From:
Sent: 05 January 2025 17:21
To: DC Admin
Subject: 2024/93293 - 17 Honeysuckle Lane - Objection to planning proposals

Application Number: 2024/93293

We are writing in respect of the above planning application for the erection of a 2 storey rear extension with a balcony.

Drawing Title  
 PROPOSED

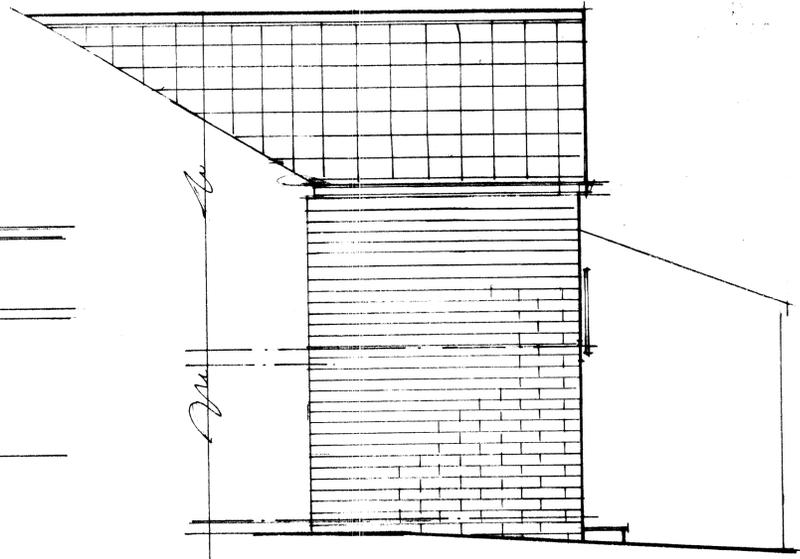
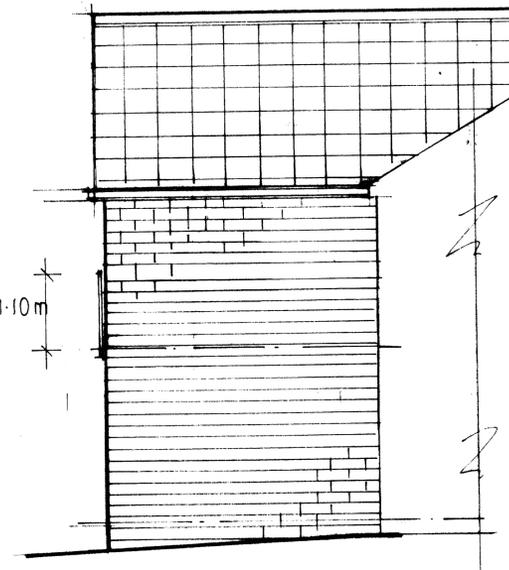
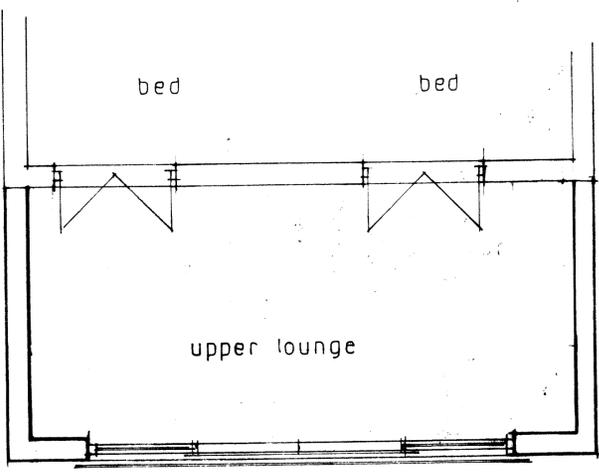
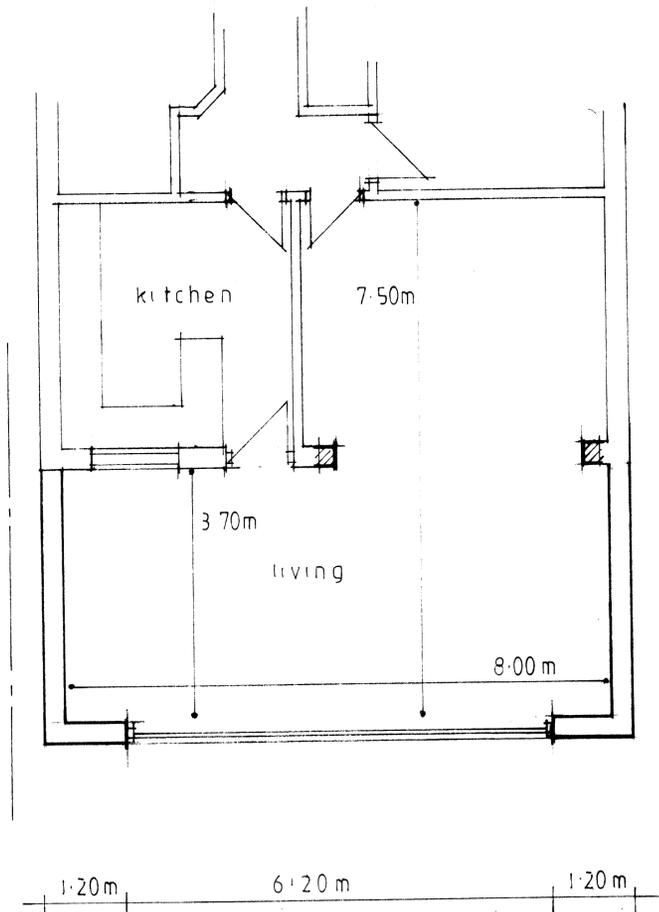
The proposed extension will result in a loss of privacy. The proposed balcony directly overlooks our garden and will also allow the occupants to view into our property. As a result we are likely to suffer loss of amenity and the ability to enjoy the quiet and private use of our kitchen/dining area, rear bedroom and garden space.

The proposed extension will severely overshadow our garden given its proximity, height and the grading of the land. The property is on higher land than our own which means that the proposed extension will inhibit our sunlight, significantly reducing the amount of daylight hours we are able to enjoy.

The proposed extension will block our rear property view. We currently enjoy a beautiful view of greenery at the rear of our property and this was a key influence when choosing to purchase our property. Our homes are in a high density area and the small distance between our respective properties would mean that the proposed extension would block this view significantly.

The proposed extension does not align with the existing surroundings. The design is out of character for the new build development and contains a balcony which differs from all properties on the street. This feature does not respect the street pattern or scales and proportions of the surrounding buildings. It would make the new development stand out disproportionately.
